**ADC Planning Consultation
Conservation/Design Officer Response**

Application Number	LU/153/17/L & LU/152/17/PL
Address	Friends Meeting House, 23 Church Street, Littlehampton
Description	Alteration and addition to Grade II listed building
Case Officer	Andrew Wood
Date	1 June 2017

First Floor

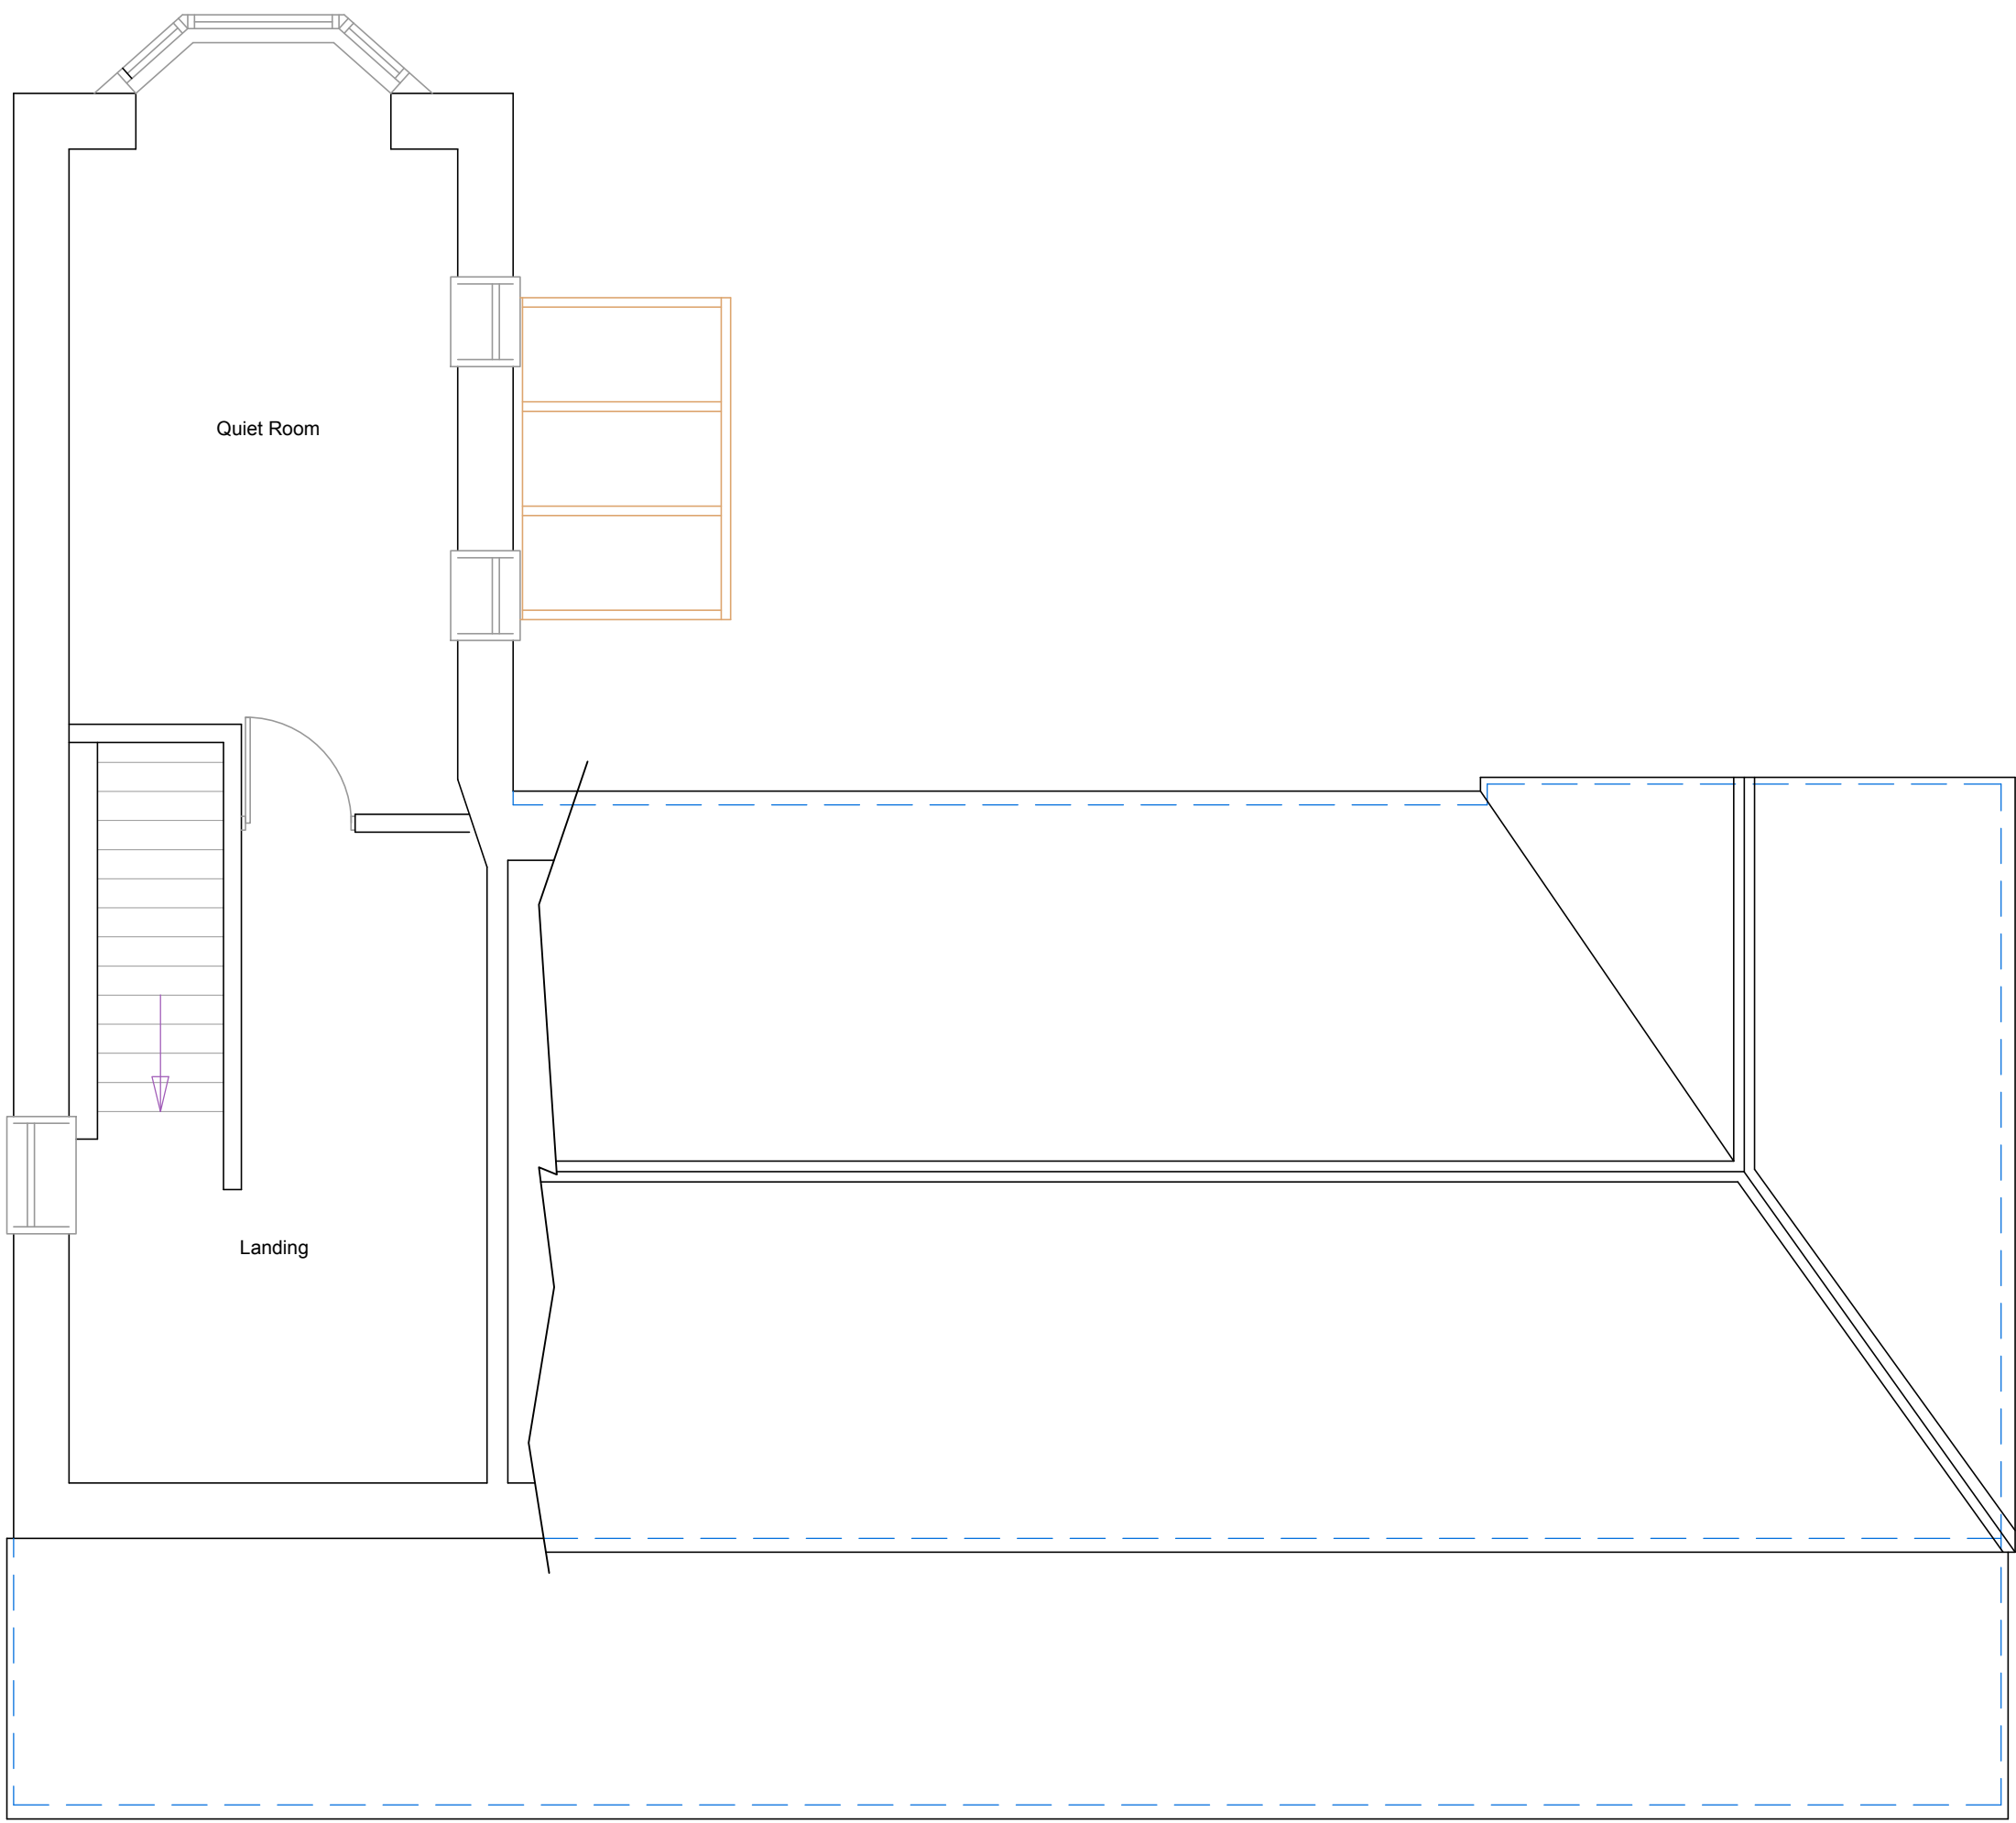
There is no objection in principle to minor adaptations to the building which facilitate disabled access without harming the significance of the heritage asset. However the proposed front porches and the new storeroom clutter the principal elevations, obscure important architectural features and considerably alter the appearance of the building. The new structures result in little material benefit and their intrusive visual presence diminishes the distinctive aesthetic qualities of the heritage asset, thereby harming its significance.

The harm to the aesthetic qualities of the listed building is not mitigated by any improvement in access for disabled users, as the porches do not materially alter the present arrangements. The proposed storeroom is not essential to keeping the building in sustainable use and there is no justification for siting a utilitarian structure in such a prominent location.

Provided the plumbing for the new sink is attached to the interior surface of the wall and causes no loss of historic fabric, there is no objection to this element of the proposal.

The information provided in support of the work to the interior wall of the main Meeting Room is insufficient to allow a full understanding of its potential impact on the significance of the heritage asset (Ref NPPF para 128).

- Evidence must be provided that the alteration is essential to allow wheelchair access to the room (ie. that a wheelchair cannot pass through the existing door openings)

- An assessment of the significance of the affected fabric must be provided. (ie. whether it is part of the original structure, or later work)
